20 July 2020

**T&CP (Development Management Procedure) (England) Order 2015
& Planning (Listed Buildings & Conservation Areas) Regulations 1990**

**HEYFORD PARK CAMP ROAD UPPER HEYFORD BICESTER OX25 5HD
Application No. 18/00825/HYBRID**

Historic England Advice

# HEYFORD PARK - DEMOLITION & CHANGE OF USE PLAN

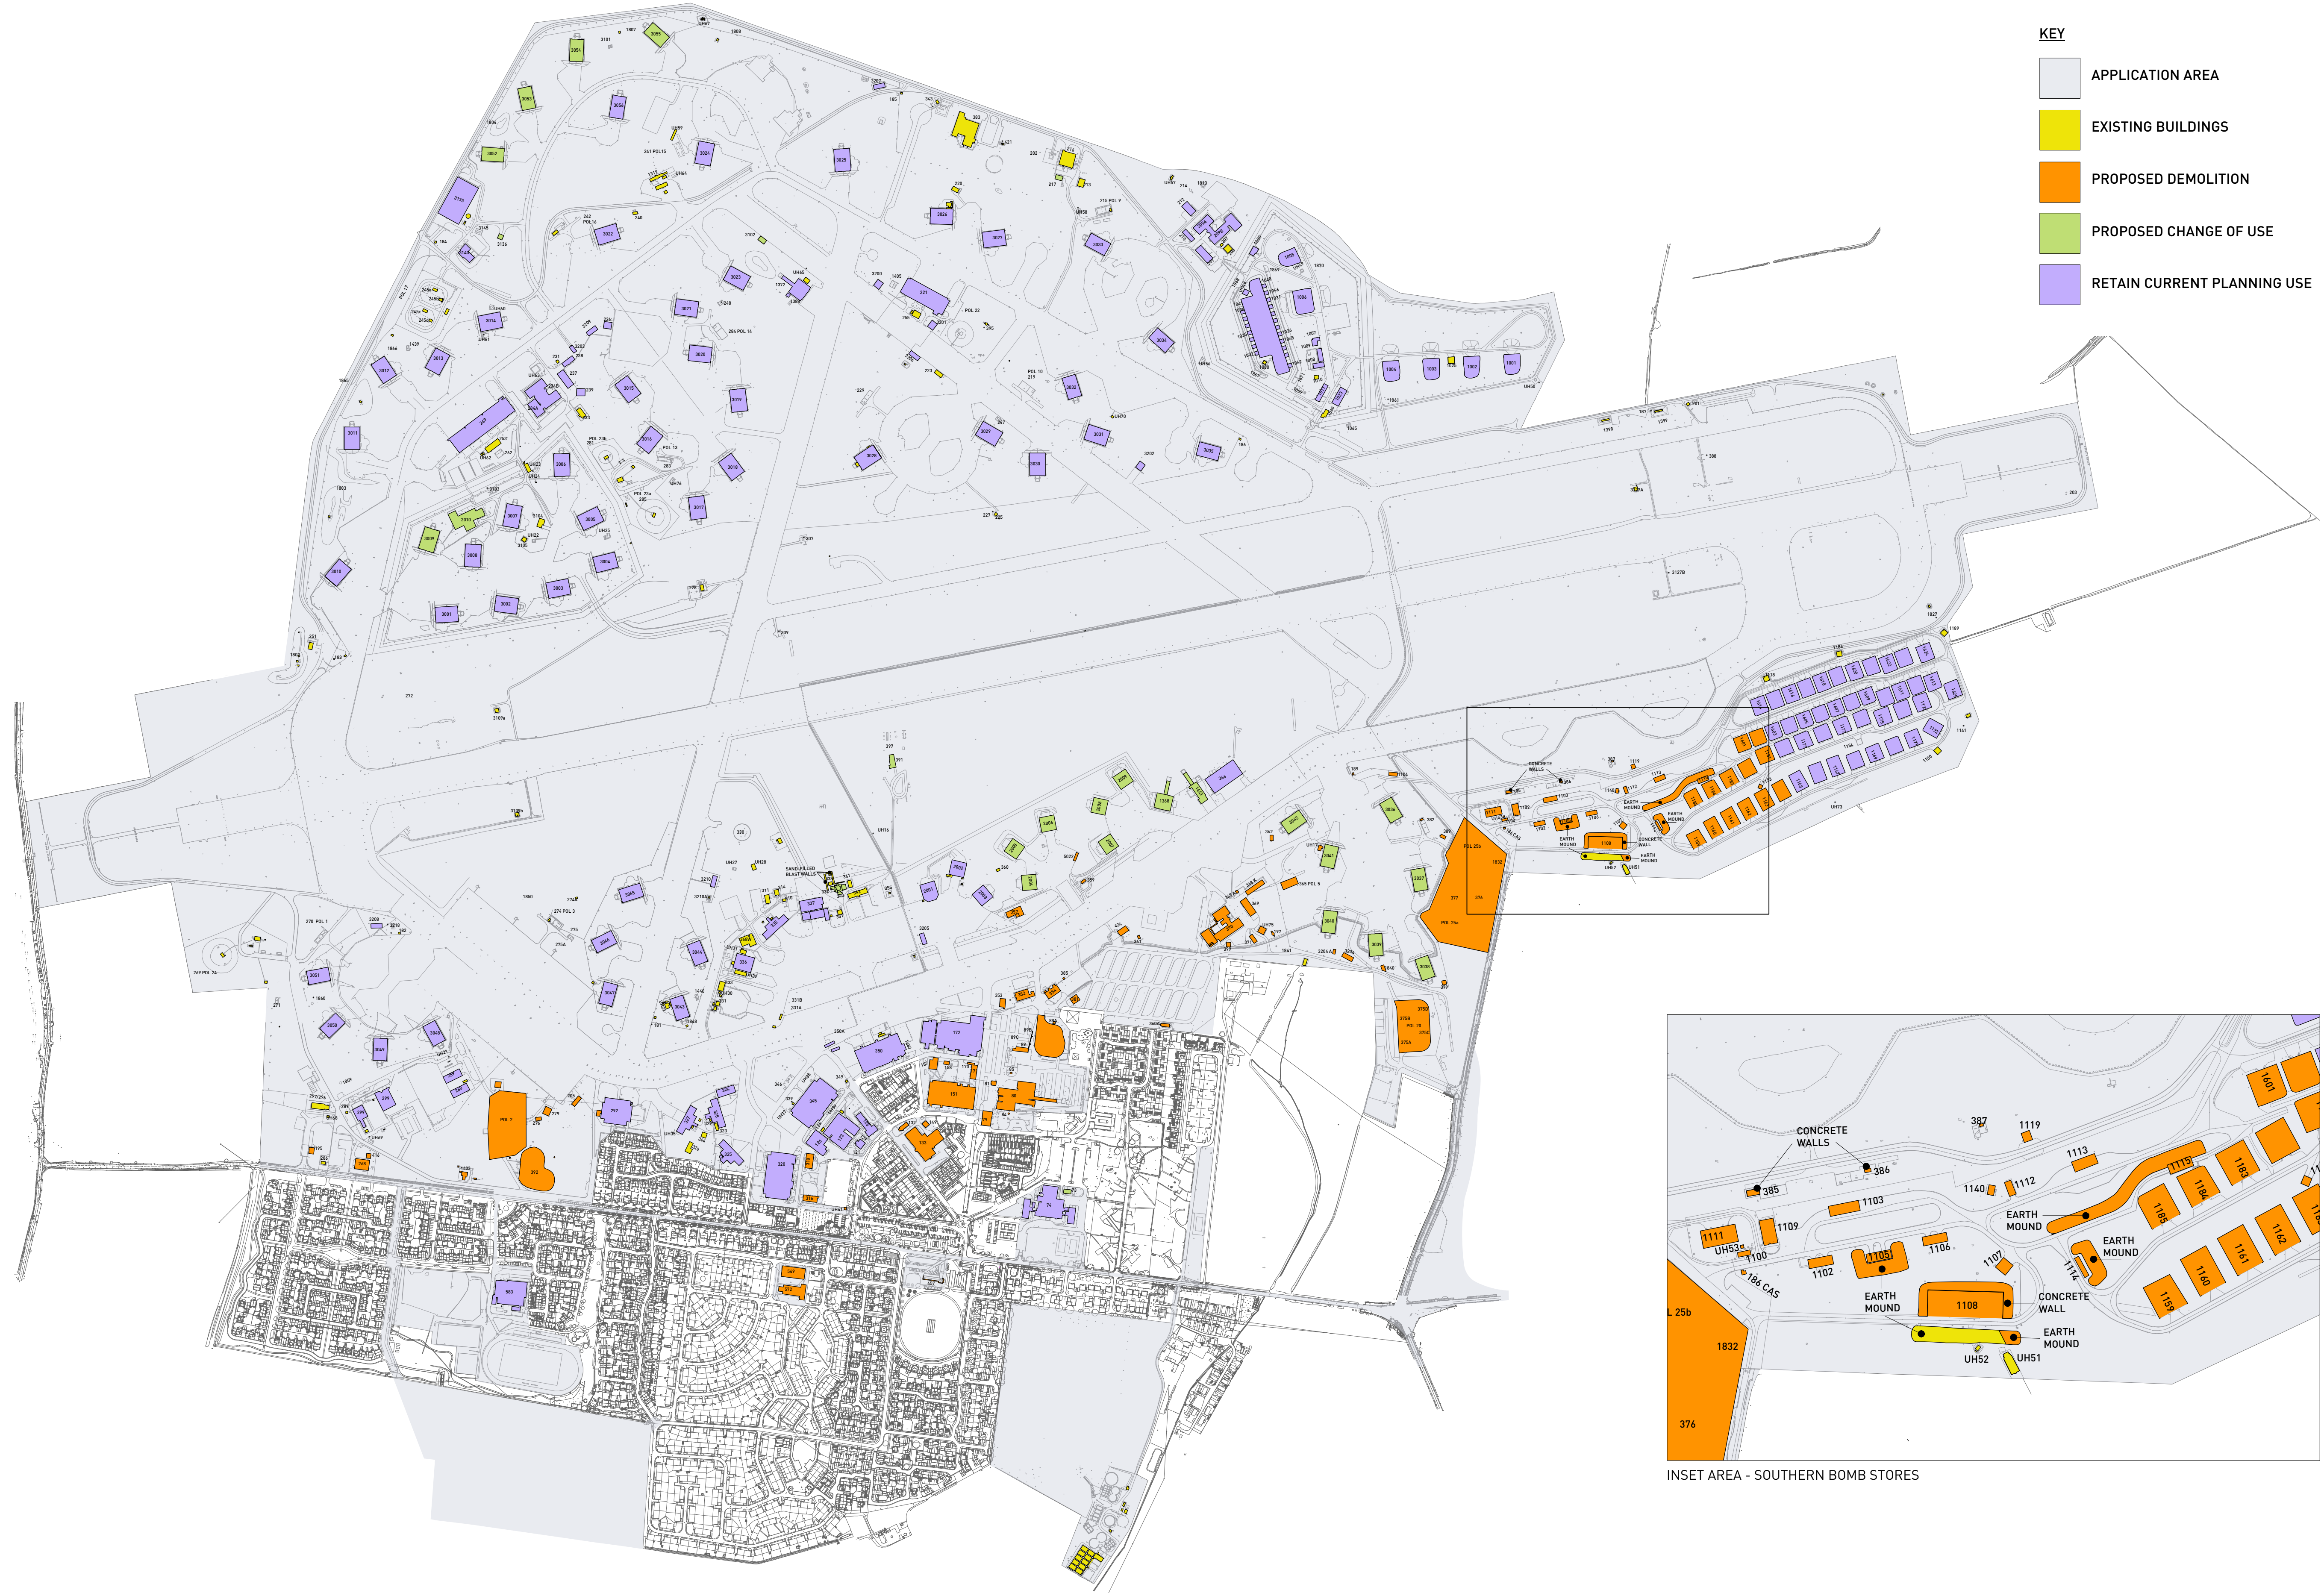
Our concerns regarding the scale of development proposed for the creative city and the lack of a clear and convincing justification for the demolition of buildings identified as making a positive contribution to the conservation area, particularly A-type hanger 150 and Squadron HQ 370 still stand.

**Sketch Masterplan: Parcels 12, 21 and 23**

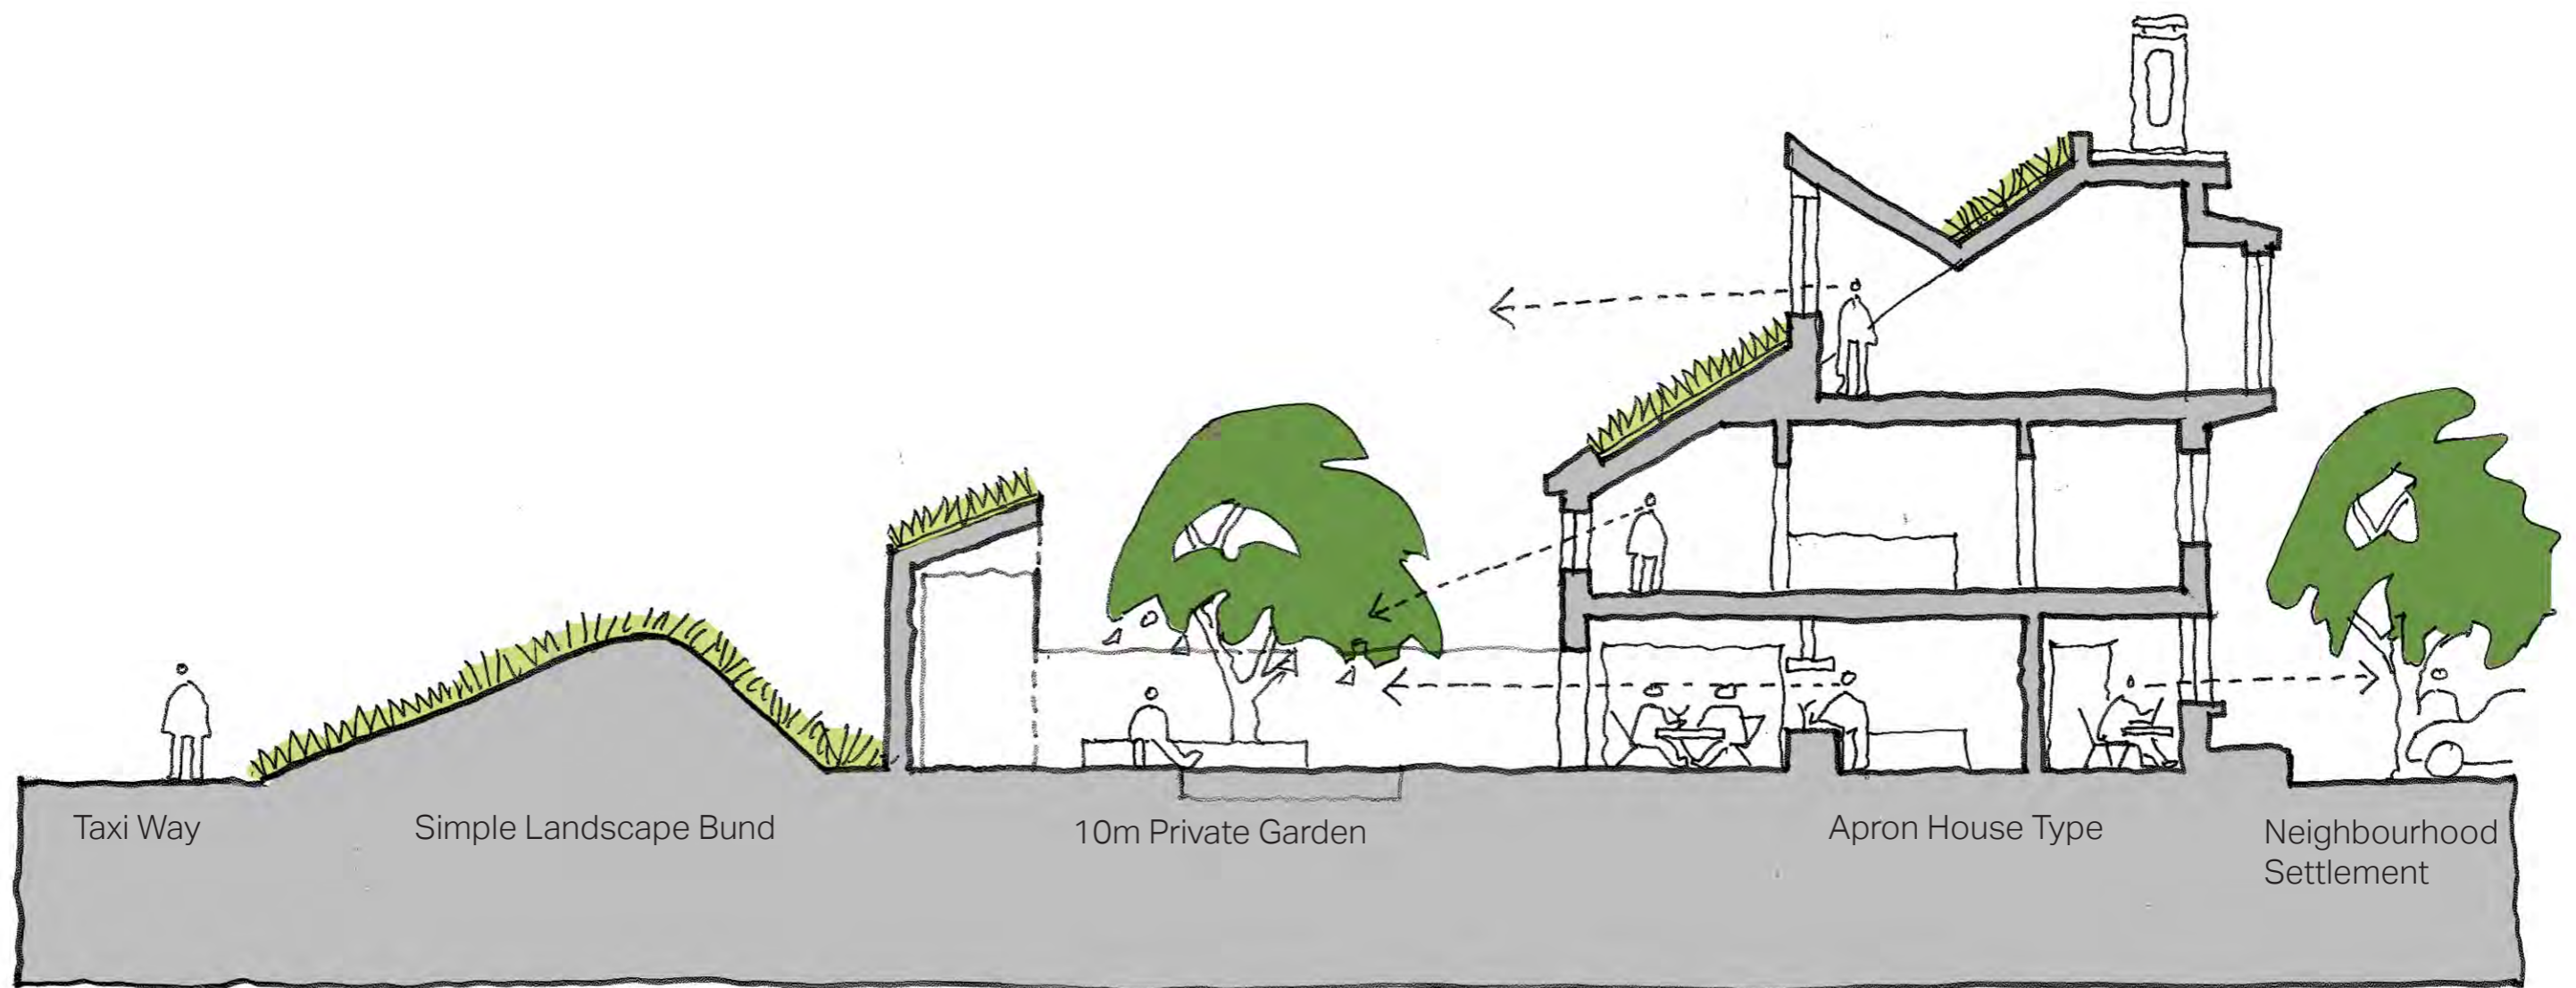
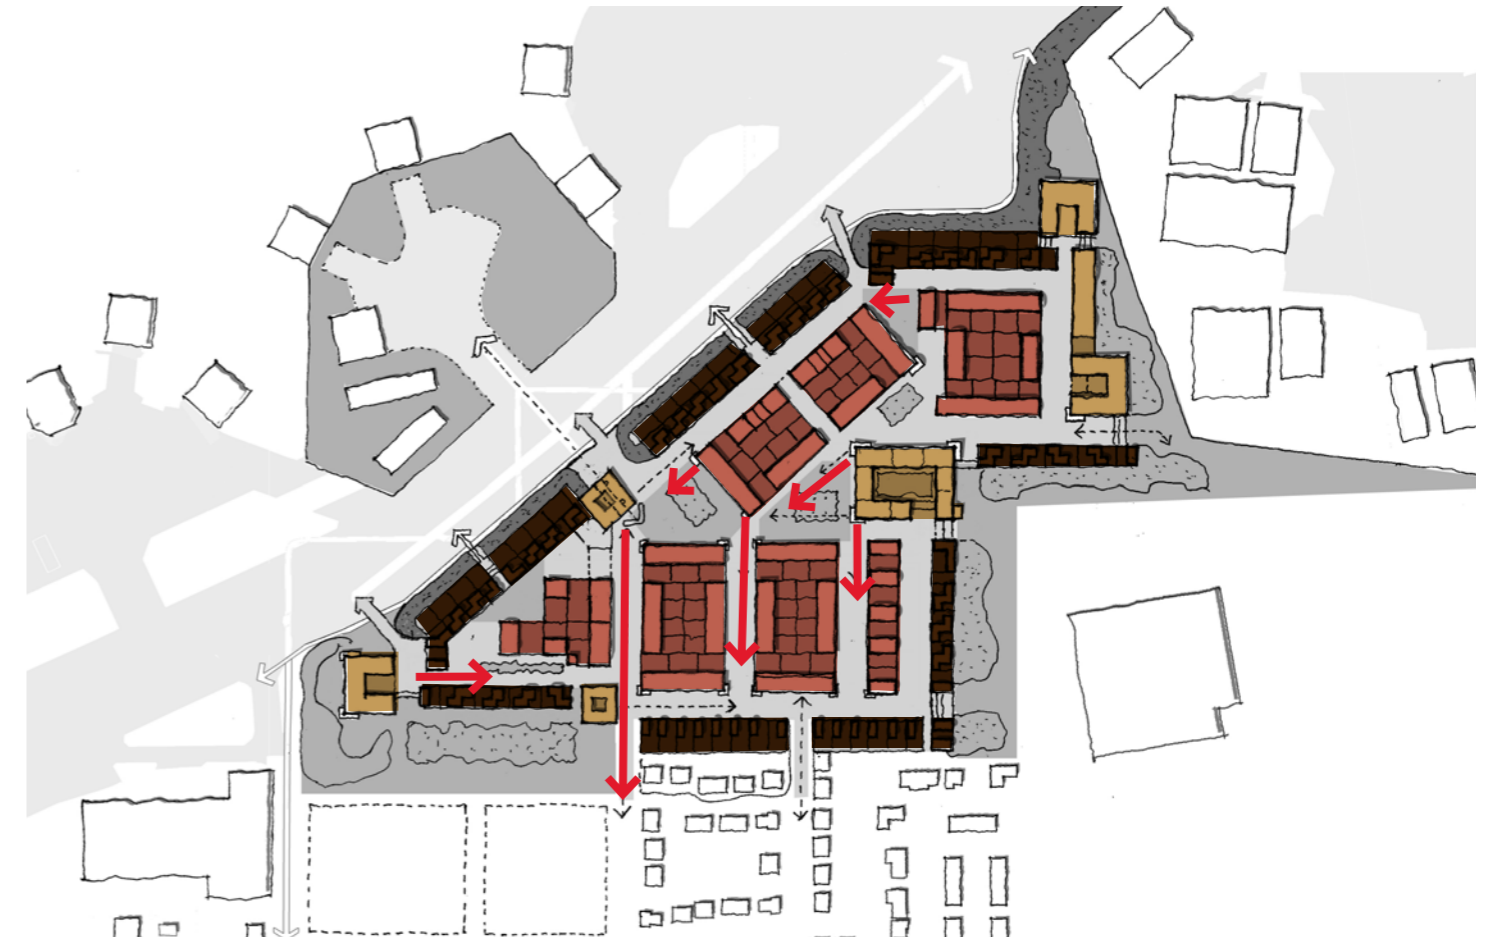
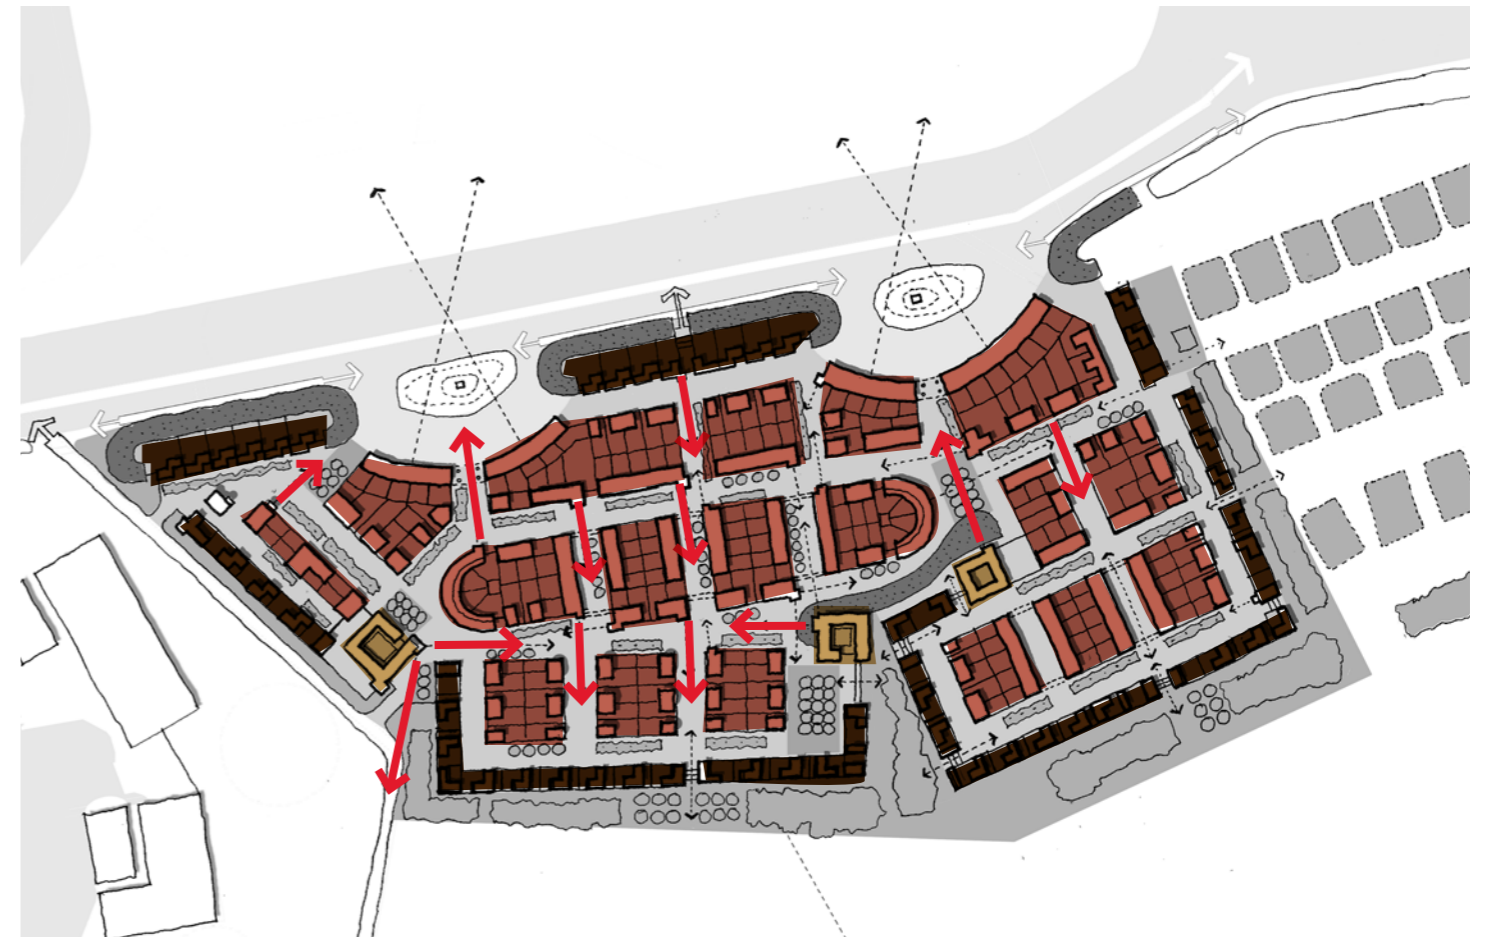
In response to concerns raised by ourselves and others about the form of housing proposed the applicants have submitted a strategy document prepared by Proctor and Matthews, one of the practices contributing to the charrette. This outlines broad development principles for the parcels in question. This proposes a low bund and that houses fronting the flying field have pitched green roofs to continue the effect of a bund. This idea has much to recommend it and there is clearly the potential to develop

the concept into a fully worked up scheme of innovative houses that could respond positively to the character of the flying field. However the current document is a broad concept and there is much work to be done, particularly concerning the street layout architectural approach and ensuring a positive connection between the housing and flying field. Furthermore, while this document sets out interesting ideas its status is unclear; at present there is no means of ensuring that the design strategy has any bearing on what is actually built on these sites. The surest way of ensuring design quality would be to work up a full application for this part of the site, or at least the elements directly fronting onto the flying field. Until and unless it can be demonstrated that there is a solid mechanism for ensuring that the good ideas set out in the design strategy are delivered if these plots are built out the concerns we have consistently raised about development on these plots still stand.
